Development Control
Ribble Valley Borough Council

Re: Planning Application 18/0837

**Address: Former Household Waste Recycling Centre off Whalley Road,
LANGHO**

**Description: Development of the former waste recycling center to create four
class B1/B8 business units.**

**5625 - 11** Rev C

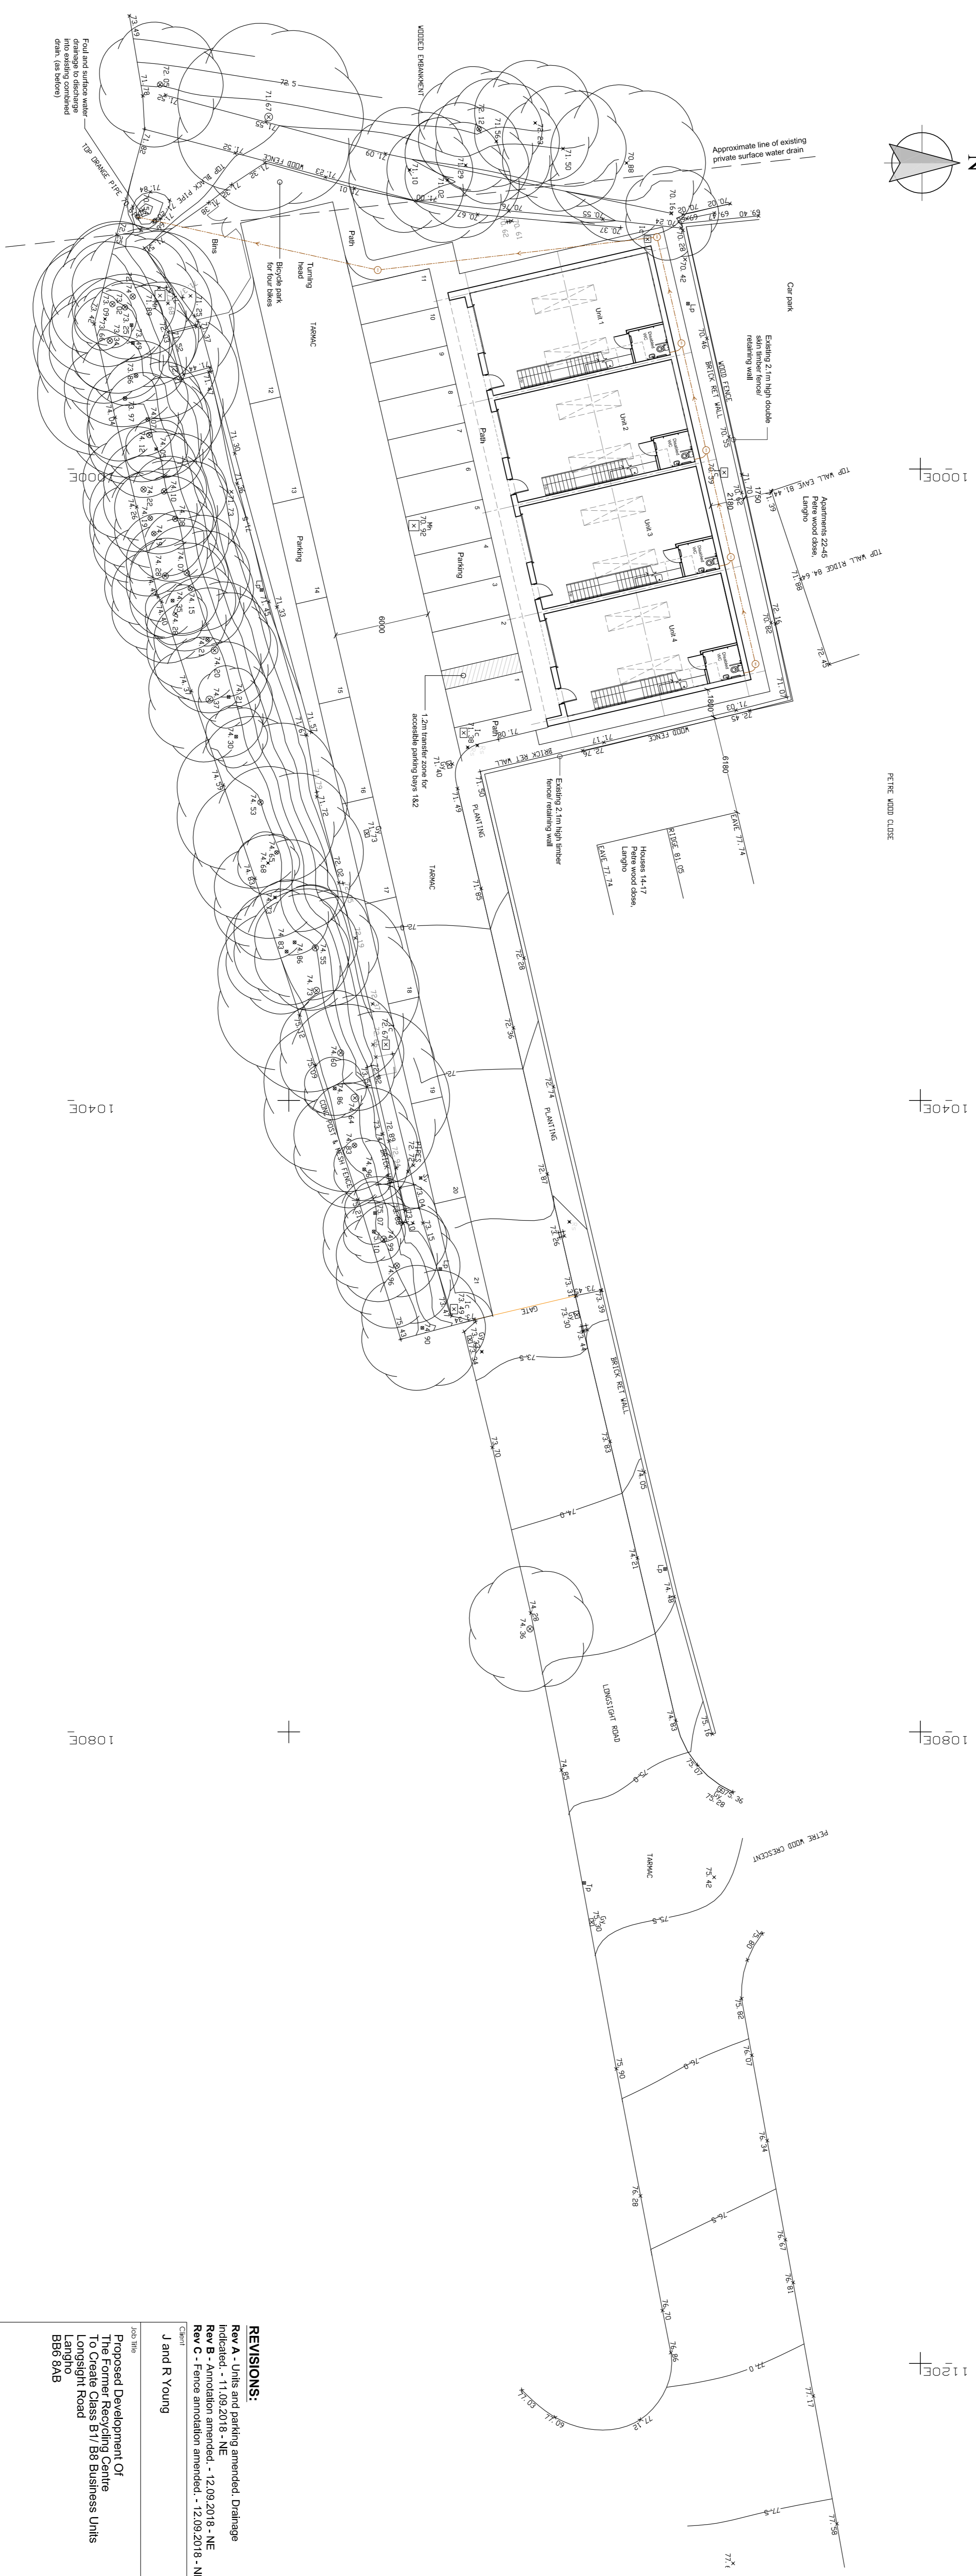
With respect to this application we would not wish to raise an objections. Following further submissions earlier concerns have been addressed and are shown on Plan No 5625 – 11 Rev D.

1. All gates and associated mechanisms to be located outside the adopted highway and the gates to have physical restraints to prevent the gates from opening onto the adopted highway. **Reasons** to ensure the adopted highway is not obstructed by the gates or are a hazard to other road users.
